An  
Bord  
Pleanála

**Board Direction**  
**BD-007486-21**  
**ABP-308431-20**

The submissions on this file and the Inspector's report were considered at a Board meeting held on 05/02/2021.

The Board decided to grant permission generally in accordance with the Inspector's recommendation, for the following reasons and considerations, and subject to the following conditions.

2 Proposed Site Layout - Public Road works  
1:500

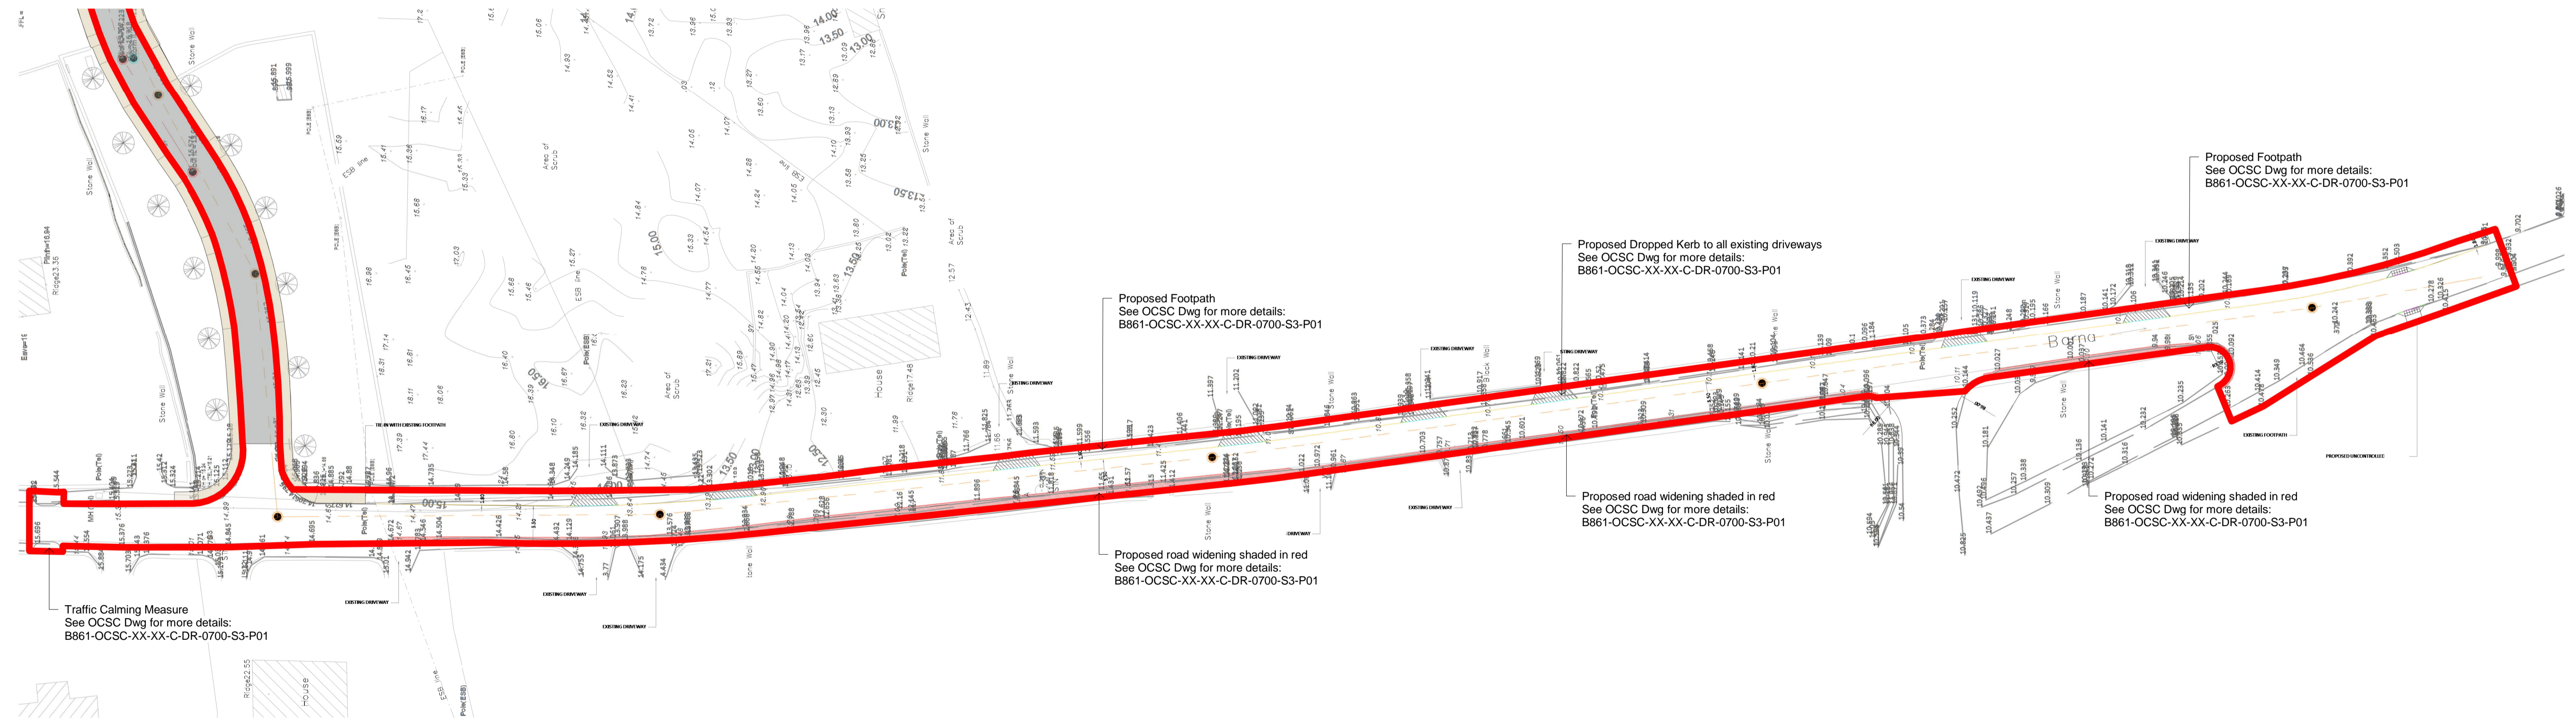
3.	<p>The proposed development shall be amended as follows:</p> <ul style="list-style-type: none"> <li>(a) Detailed construction drawings and an associated construction management plan in relation to the works proposed to the L1321, including public lighting and surface water drainage, shall be submitted to, and agreed in writing with, the planning authority prior to the commencement of development. As conditioned in 17(a) hereunder no unit shall be occupied prior to the completion of the footpath and associated improvements to the L1321.</li> <li>(b) A planted privacy strip shall be provided at ground level to the apartments in Block A4, and between Blocks A1 and A2, where ground level windows adjoin public footpaths.</li> </ul>

2 Proposed Site Layout Plan - Roadworks Taking in Charge

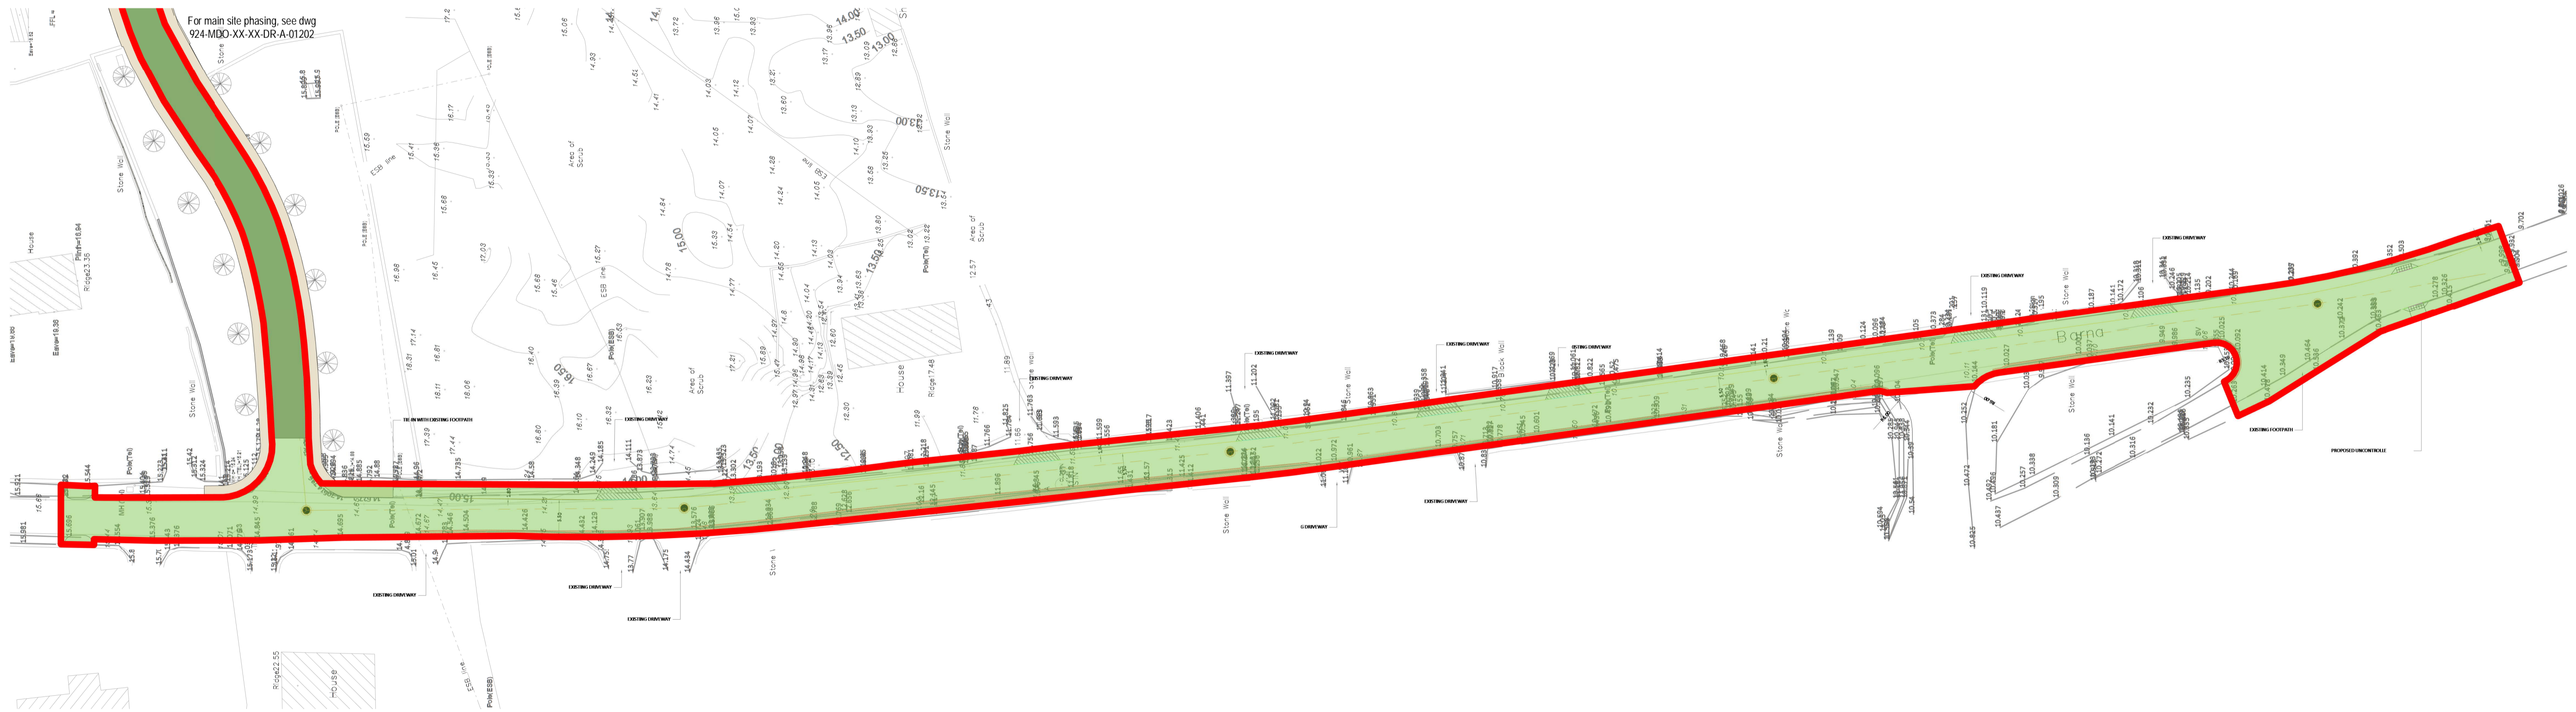
<p>any residential units and shall be completed in accordance with the detailed construction standards of the planning authority for such works.</p> <p>b) The public linear park, identified as ‘Landscape Phase 1’, ‘Landscape Phase 2’ and ‘Landscape Phase 3’ on the development phasing drawing no. 924-MDO-XX-XX-DR-01202 shall be completed in accordance with the submitted Landscape Plan as part of Phase 1.</p> <p><b>Reason:</b> To ensure the timely provision of services, and the provision of a pedestrian connection to the centre of Bearna, for the benefit of the occupants of the proposed dwellings.</p>

TYPICAL A-A LUMINAIRE
N.T.S. (A1)

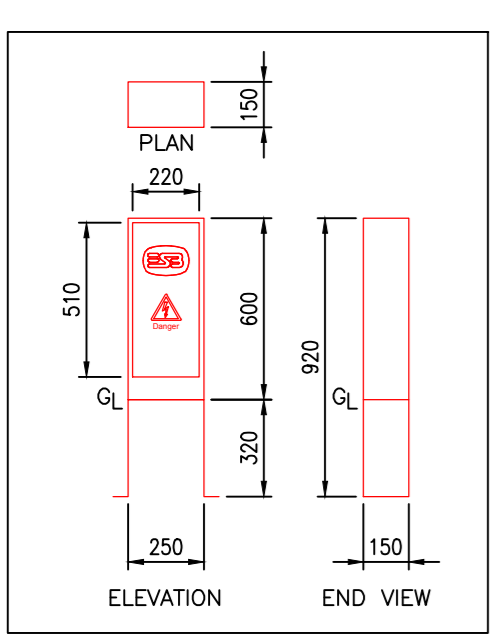
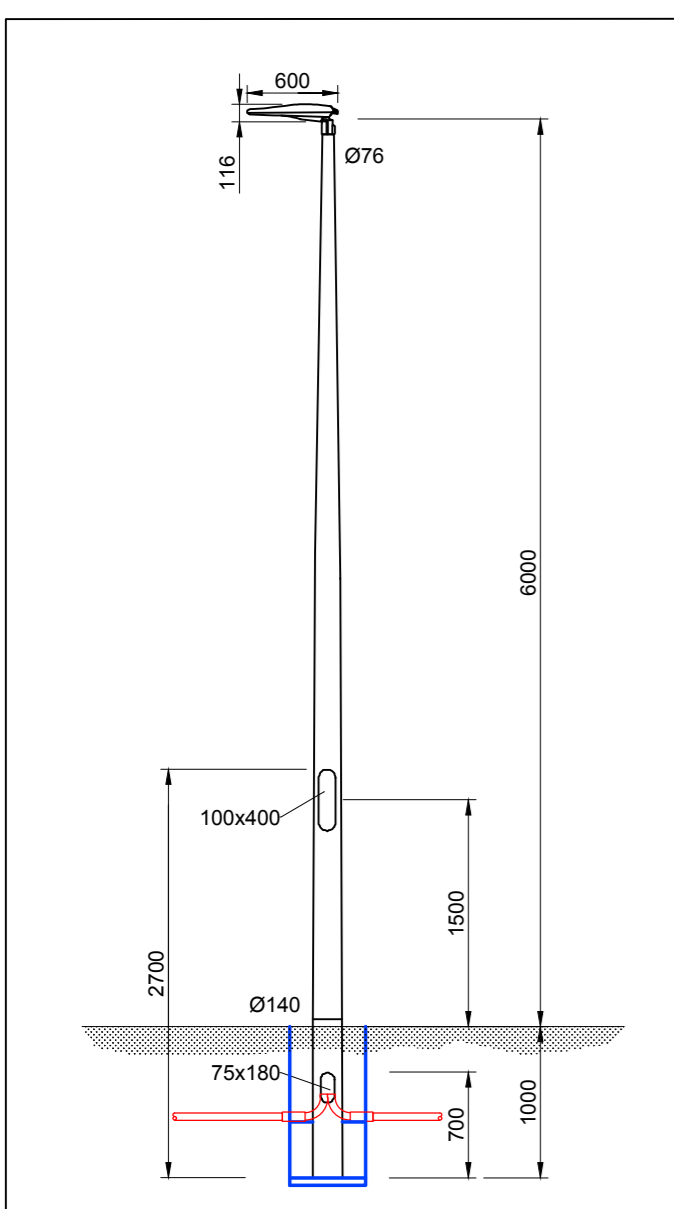
9.	<p>Public lighting shall be provided in accordance with a scheme, which shall include lighting along pedestrian routes through open spaces, details of which shall be submitted to, and agreed in writing with, the planning</p>

<p>authority prior to commencement of development/installation of lighting. Such lighting shall be sensitive to bat and otter species in the area and shall have regard to EUROBATS and Dark Sky lighting recommendations.</p> <p><b>Reason:</b> In the interests of amenity and public safety.</p>
